RE: Notice of Decision – Binder Variance (V-08-00010)

The above referenced application submitted for a 10 foot variance from the required 15 foot side yard setback to construct a shop in the Rural-3 zone, located at 170 Blue Agate Lane, Ronald, WA 98940, which is located in a portion of Section 12, T20N, R14E, WM, in Kittitas County, and having a map number 20-14-12051-0703, is hereby **DENIED**. This denial is based on the determination that the applicant failed to meet the burden of proof regarding the variance criteria contained in KCC 17.84 and as outlined below. For a variance to be approved, all criteria listed in KCC 17.84 must be met by the applicant.

RE: Comments to Johnson Variance (VA-08-10)

Site plan:
 Doug Binder
 170 Blue Agate Lane
 Ronald WA
 Parcel #
 20-14-12051-0703
 Scale: 1" = 20'
 North

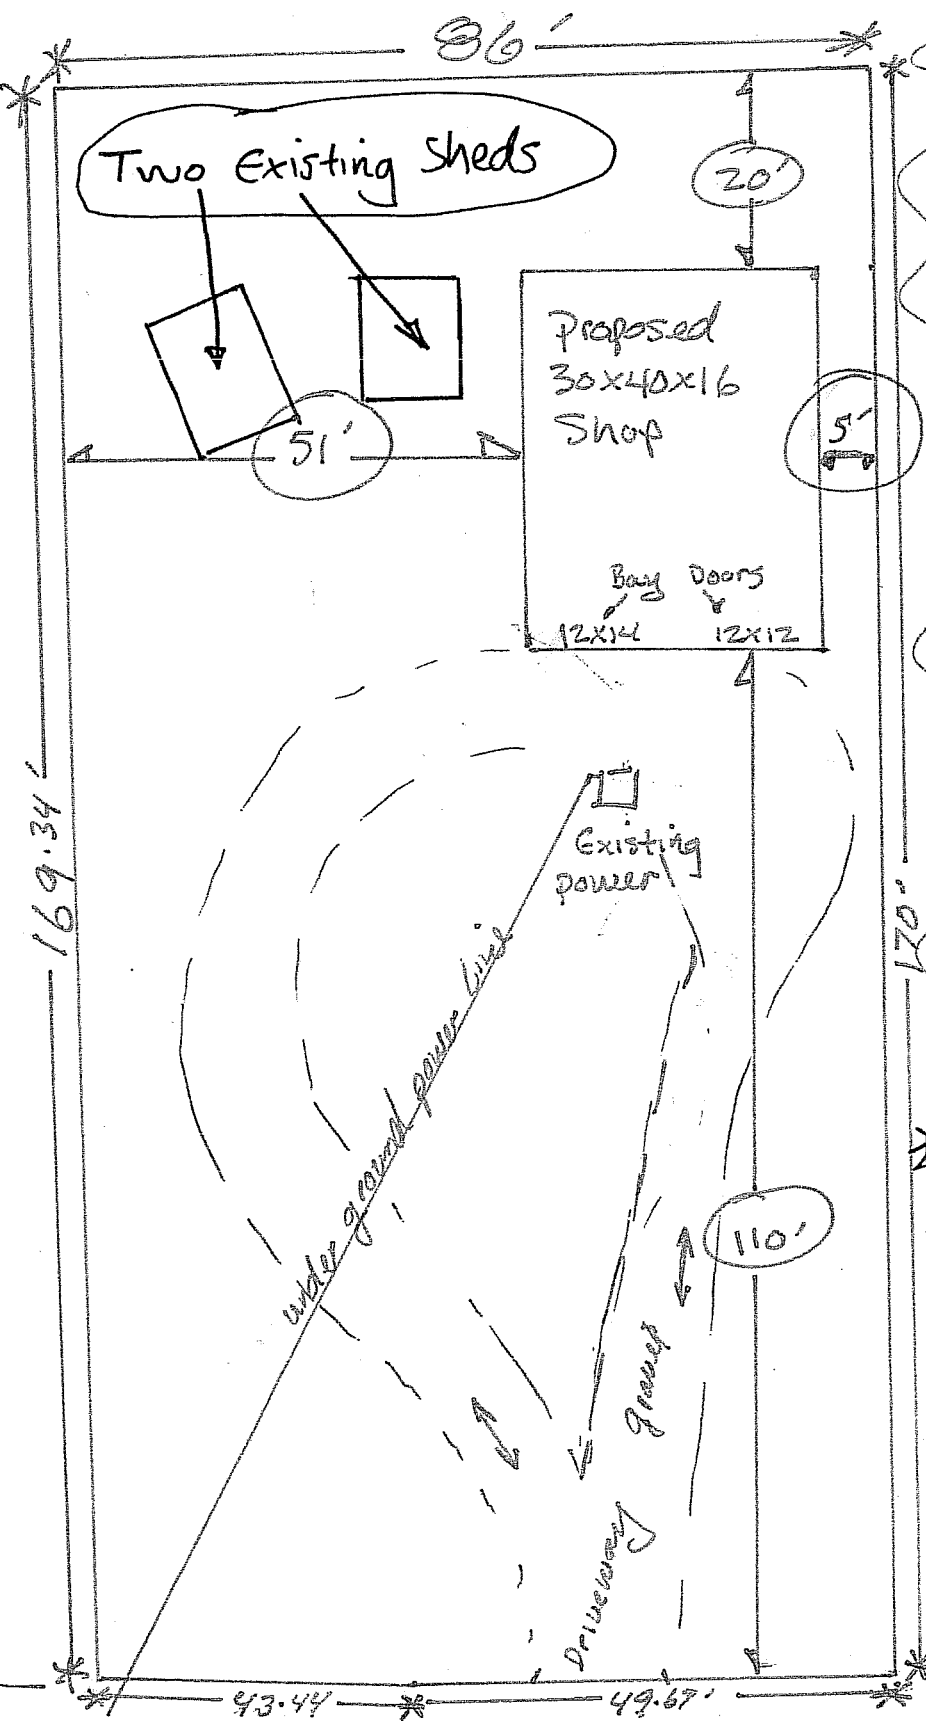
- A. Unusual circumstances apply to this property and do not apply generally to other properties in the area.
The subject property is located within the Rural-3 zoning which has a side yard setback requirement of 15 feet. The subject property has 2 small sheds that have moved locations in the past 2 years and can be moved so the proposed shop can meet the required setbacks. Kittitas County does not regulate or enforce Protective Covenants (PC's) or Covenants, Conditions, and Restrictions (CC & R's).

- B. Such variance is necessary for the preservation and enjoyment of a substantial property right of the applicant.
The property is currently undeveloped with the exception of 2 small sheds, based on historical records they have been moved within the subject property. A variance is not necessary as the existing sheds can be moved in order for the proposed shop to meet the required side yard setback of 15 feet.

- **The structure should be constructed in such a manner as to prevent snow from sliding off the roof and impacting the adjacent property.**
- **It is recommended that the structure be designed with "snow-guards" that will hold all of the snow on the roof.**
